We are the engineering company referred to in some of the reports; backing onto the propose development.

Whilst we understand the need for additional housing we do have our concerns about the work required to make that land usable and the suitability of that site.

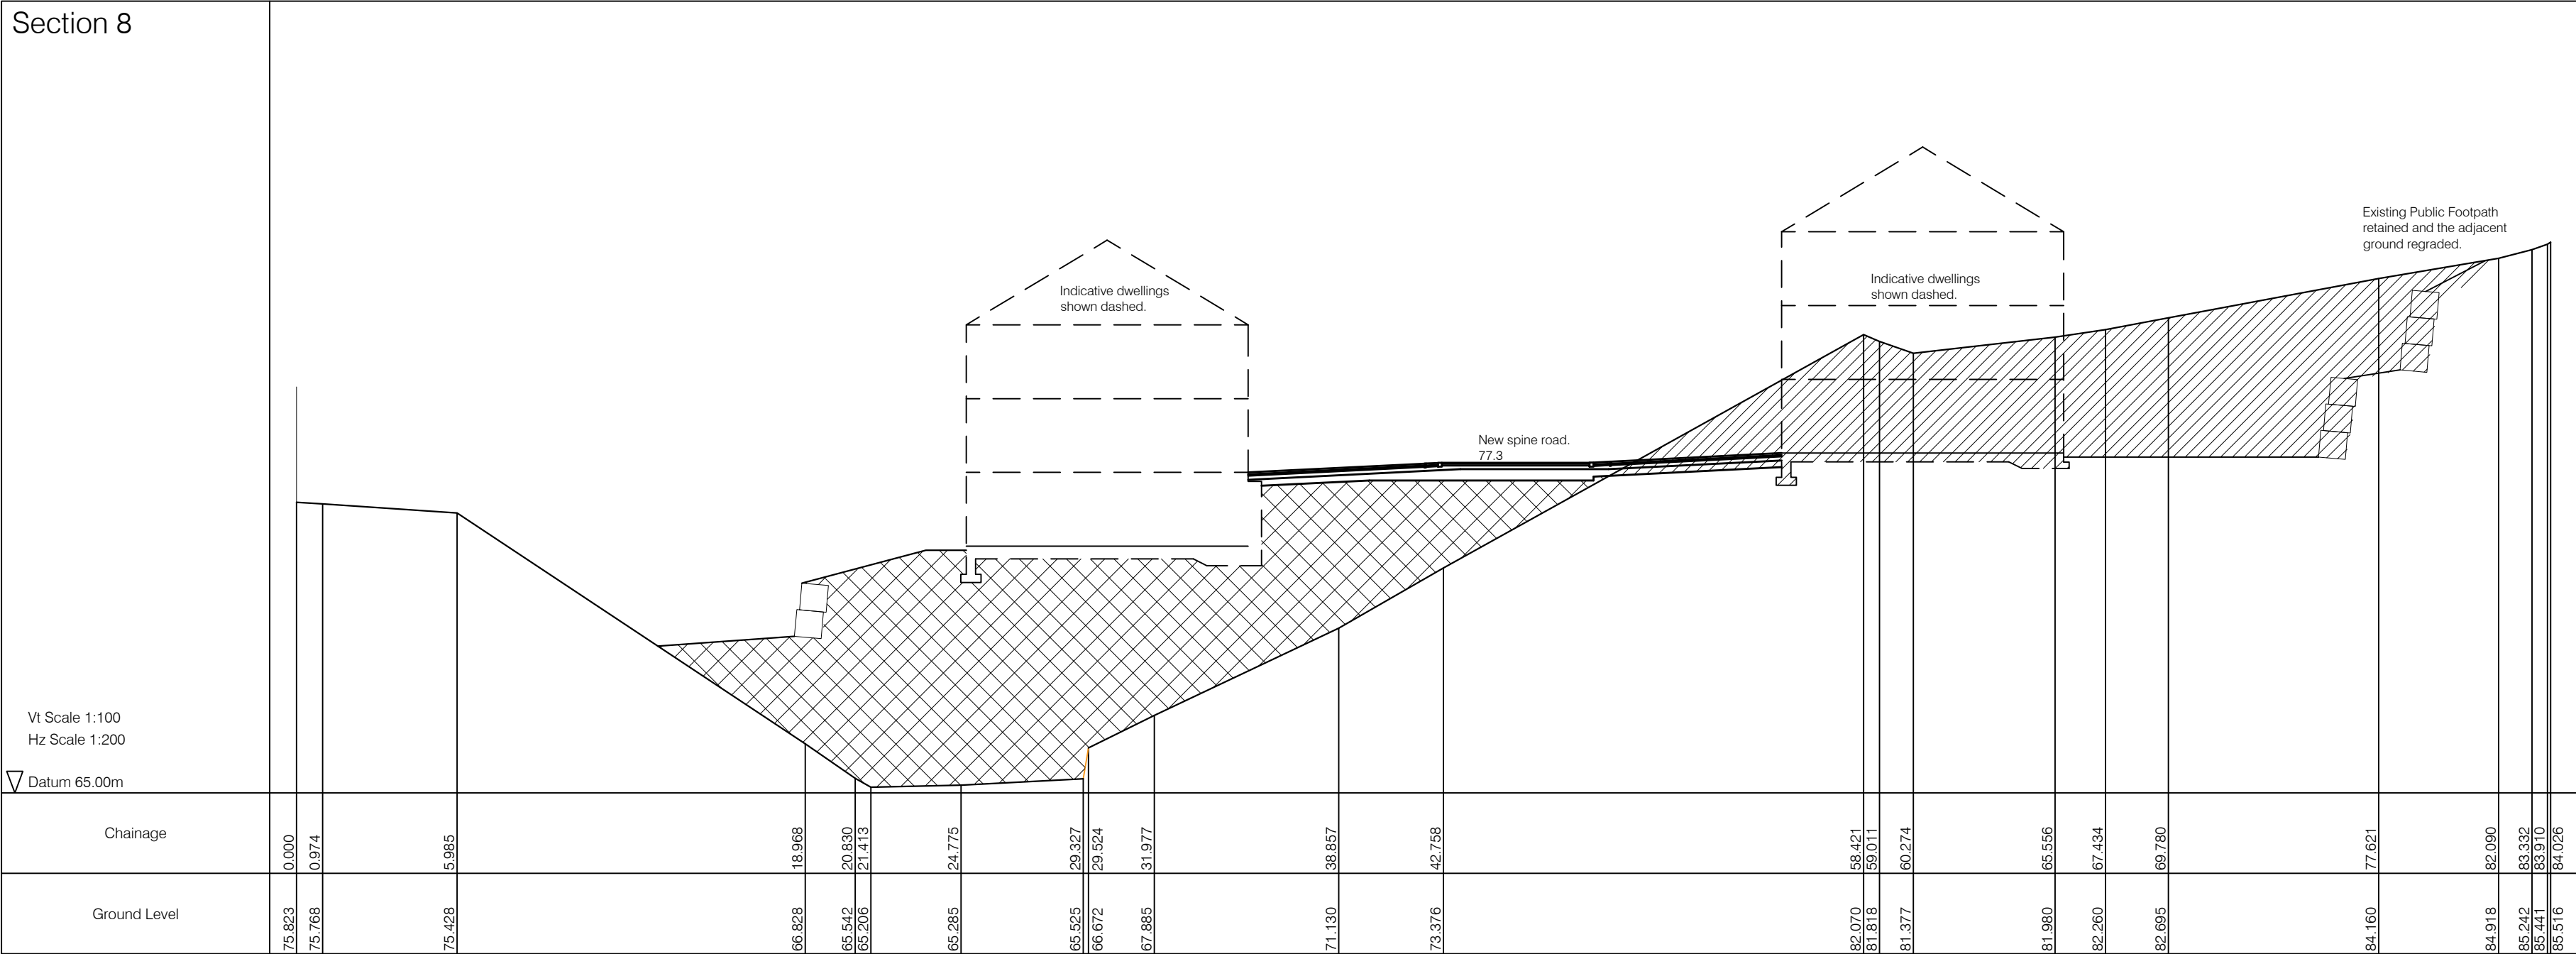
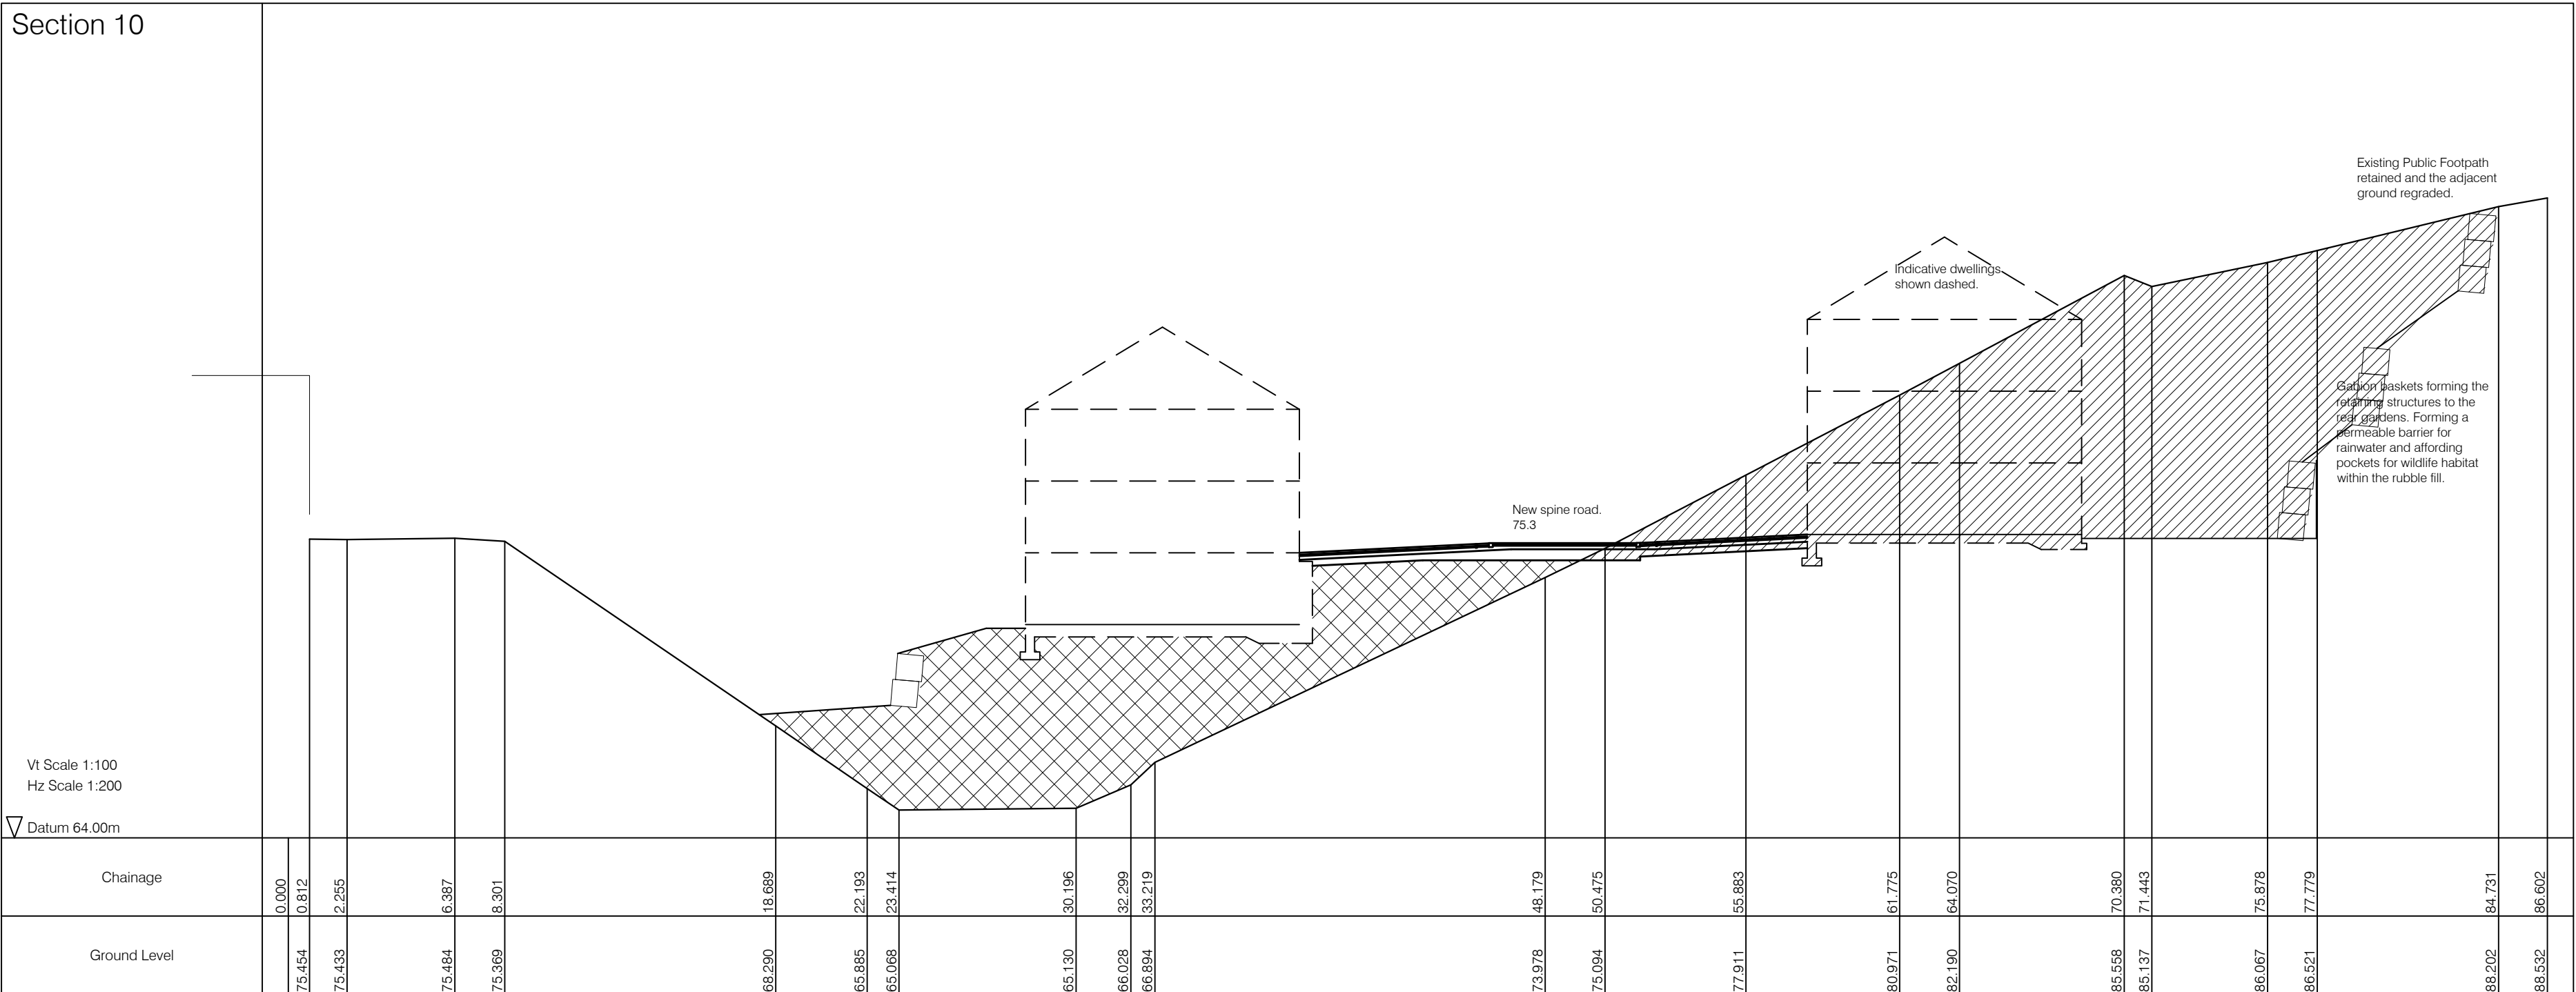
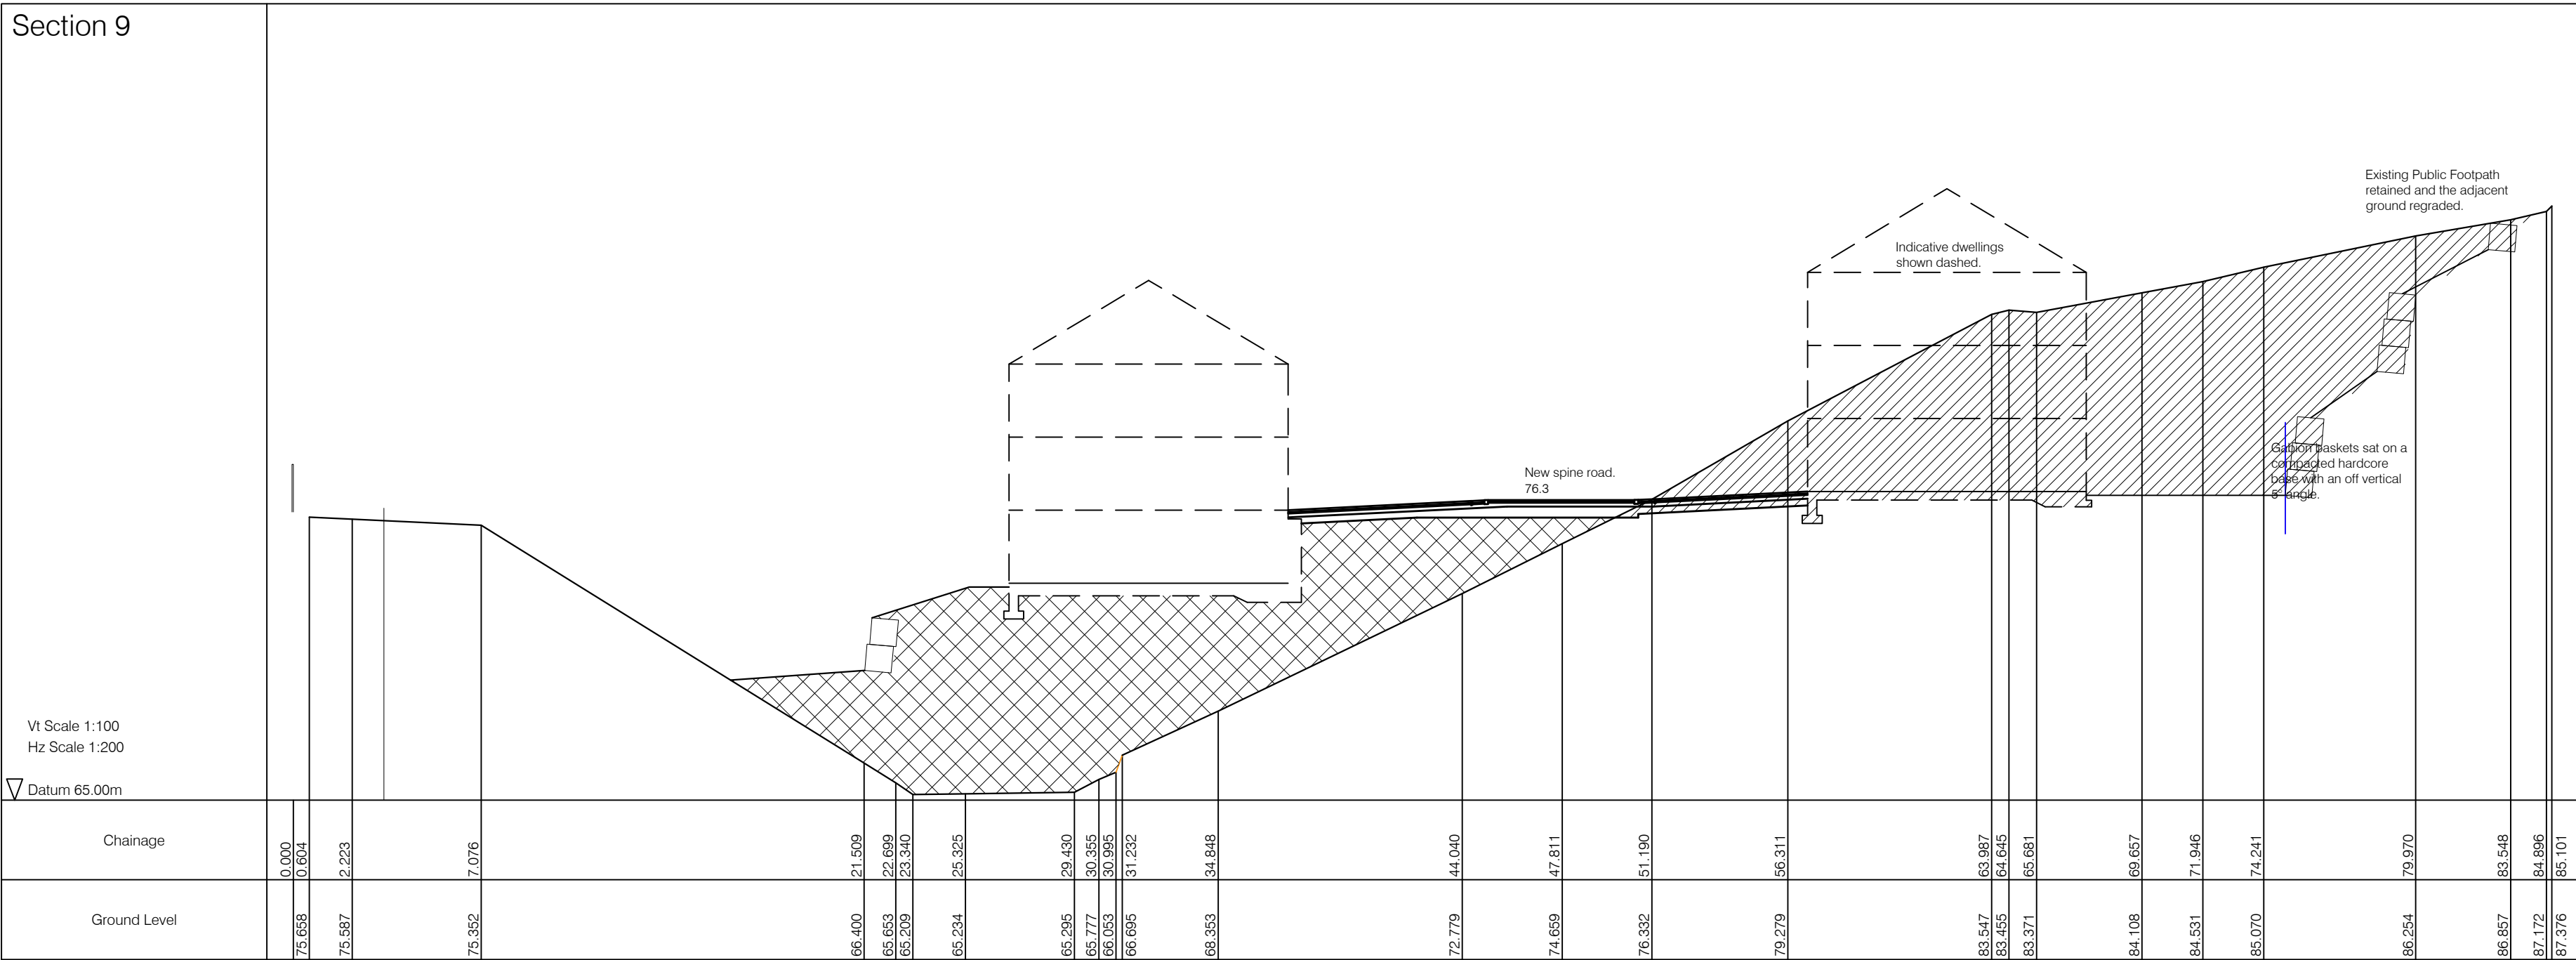
The cut and fill and the piling required worries us.

We have a concern that when the cut is started that there is a chance it could have an effect on the stability of our building. We also feel that not enough is known about the effect of the piling operation on the land stability.
